Application for Planning Permission for Works or Extension to a Dwelling

Development: Extension and alterations to form a rear facing balcony and sliding doors (part retrospective).
Location: 1 Elmer Court Elmer Middleton-On-Sea PO22 6JT

BAR/101

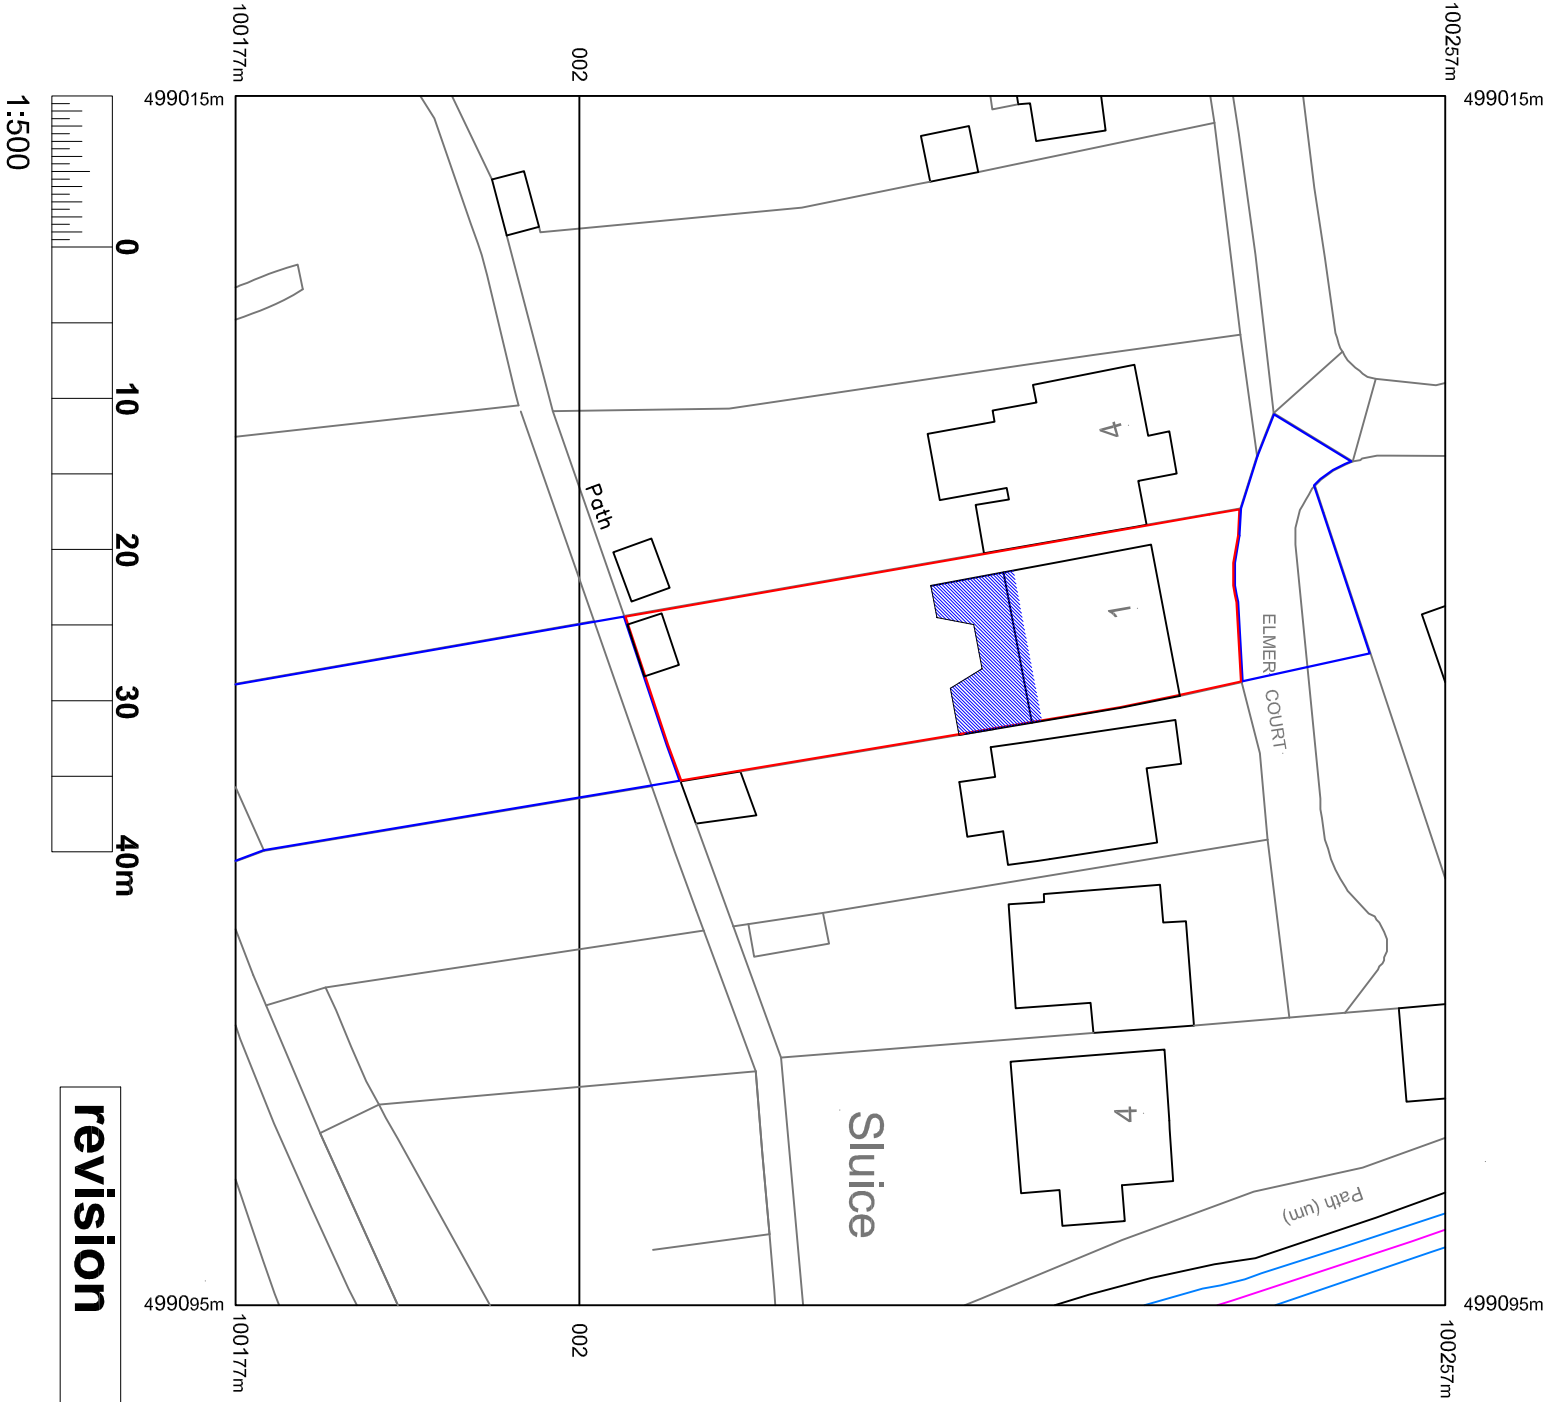
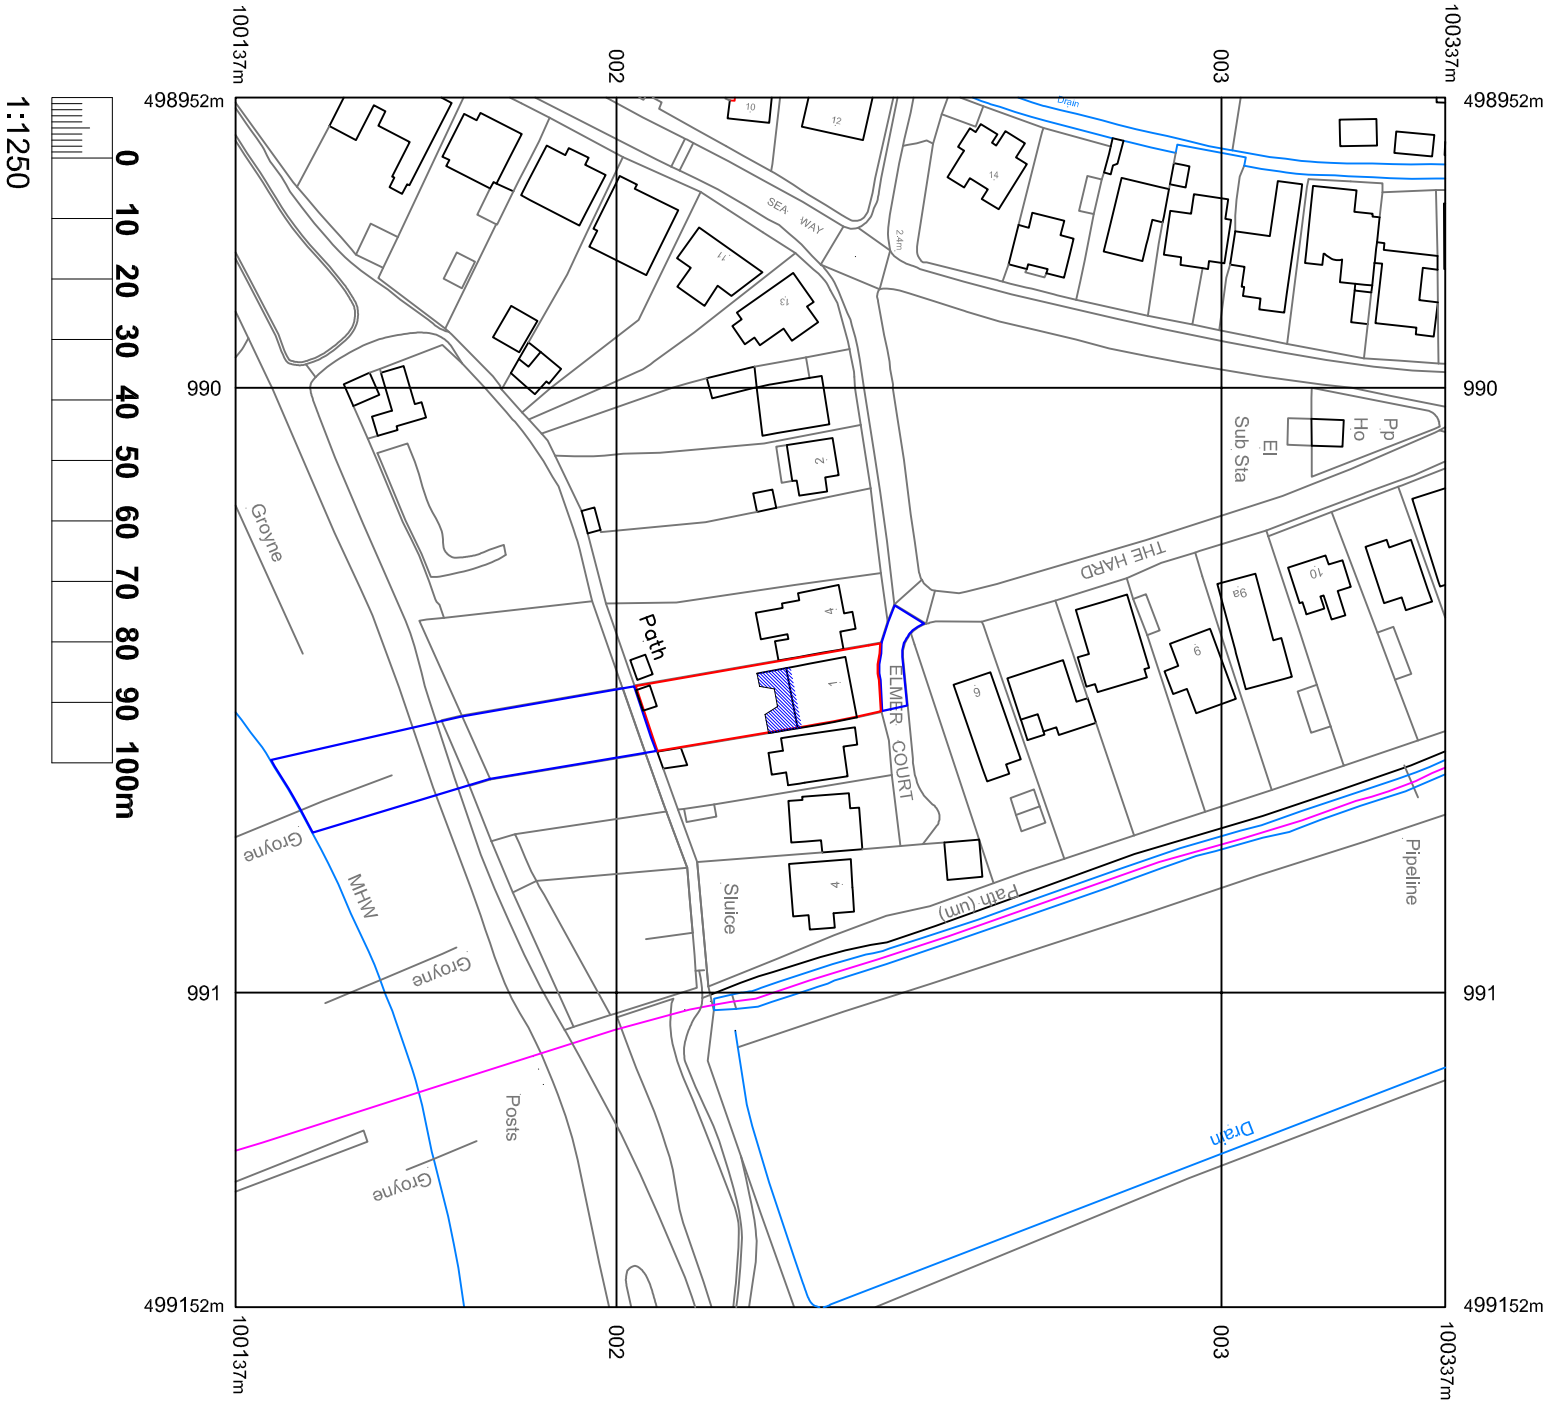
Site Plan - Please add the dimensions from the proposed balcony extension to each site boundary edge.
